Development Facilitation Team (DFT) – Review Comments

Project No: PR-2022-007299 Date: 6/26/2024 Agenda Item: #1 Zone Atlas Page: K-10

Legal Description: TRACT I, TRACTS 54 & 55, COORS PLAZA; TOWN OF ATRISCO GRANT

Application For: SD-2024-00113 – PRELIMINARY/FINAL PLAT

Plat for Tracts I-1 and I-2, Coors Plaza Being Comprised of Remaining Portions of Tract I, Coors Plaza, and Tracts 54 and 55, Unit 6, Town of Atrisco Grant City of Albuquerque Bernalillo County, New Mexico May 2023

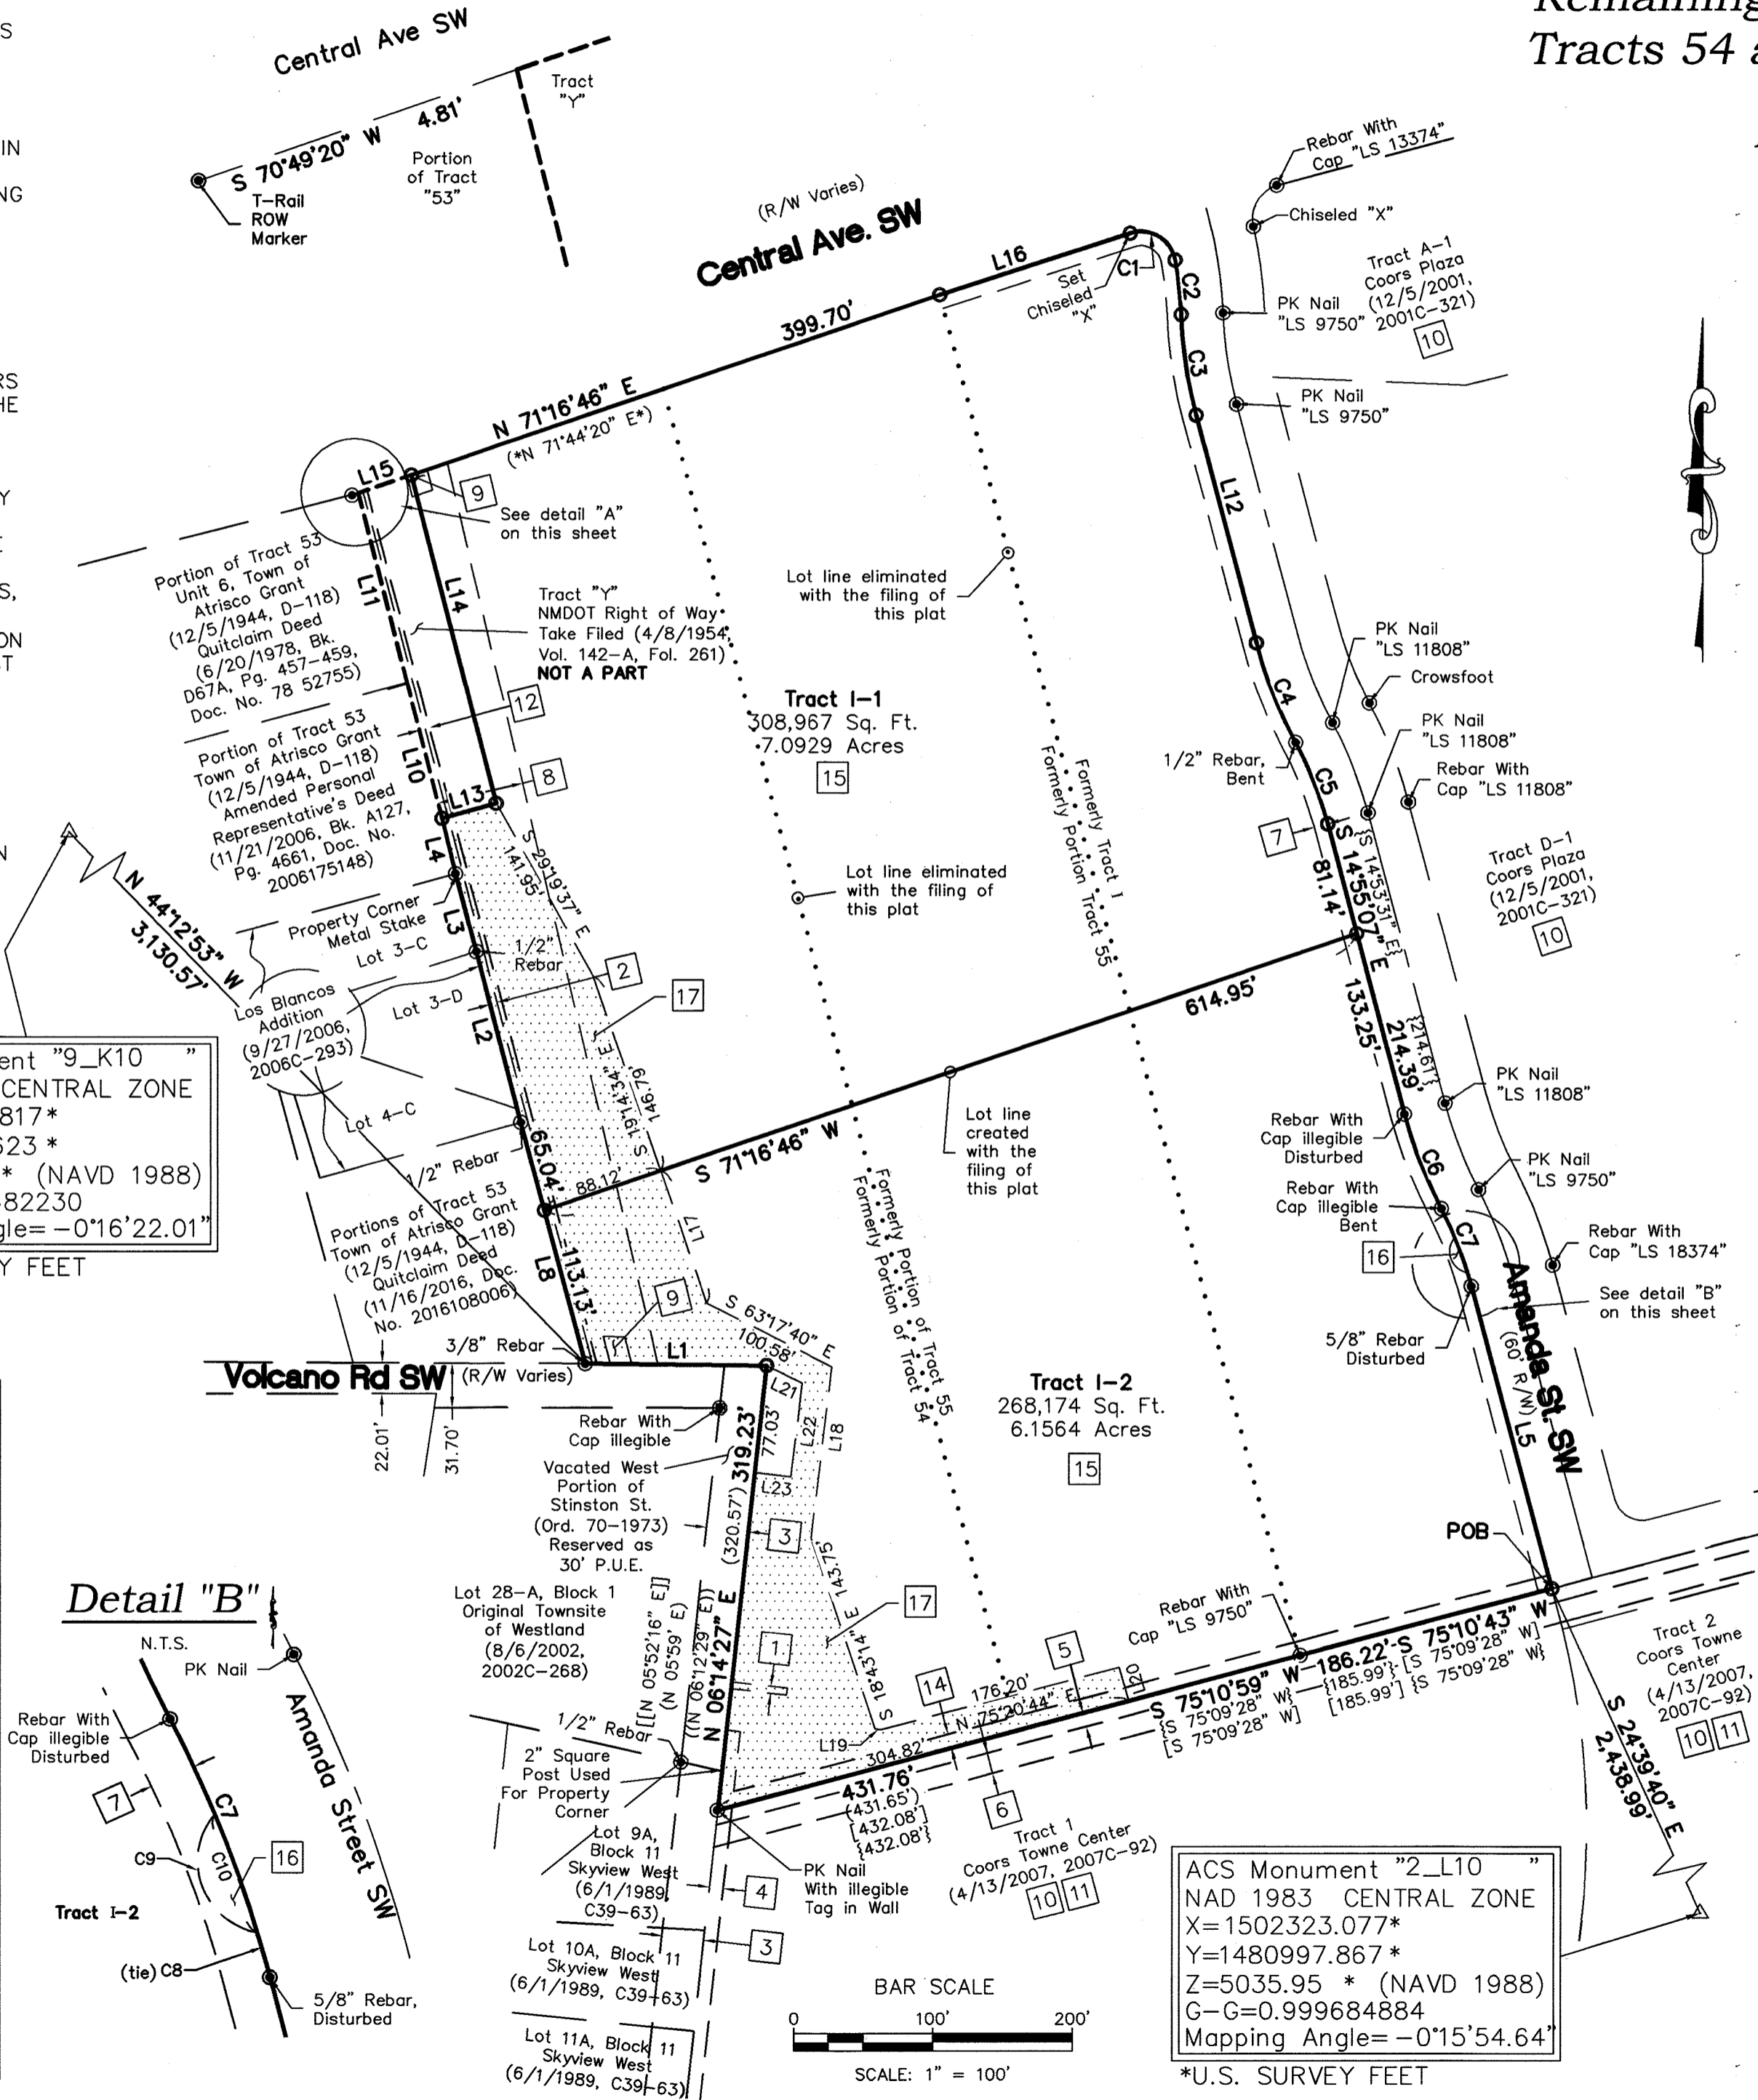
3. Please clearly identify the purpose of easement note 3 and its applicability for public water and sewer to remain within this corridor. If this is not clear, please grant a public water and public sanitary sewer easement for this infrastructure if within this property. It is not clear if this portion is part of the platted area.

- Hydrology has an approved Conceptual Grading & Drainage Plan (K10D070) with engineer's stamp 06/06/2024.
- Hydrology needs a Public Drainage Easement as shown since there is public drainage passing through this site.

- Please add the City's standard drainage easement language.
- Comment - Prior to submitting for Building Permit, a licensed New Mexico civil engineer will need to submit a Grading & Drainage Plan to Hydrology for review & approval if one of these conditions is met. (500 cy of grading, 1,000 sf of proposed building, or 10,000 sf of proposed paving).
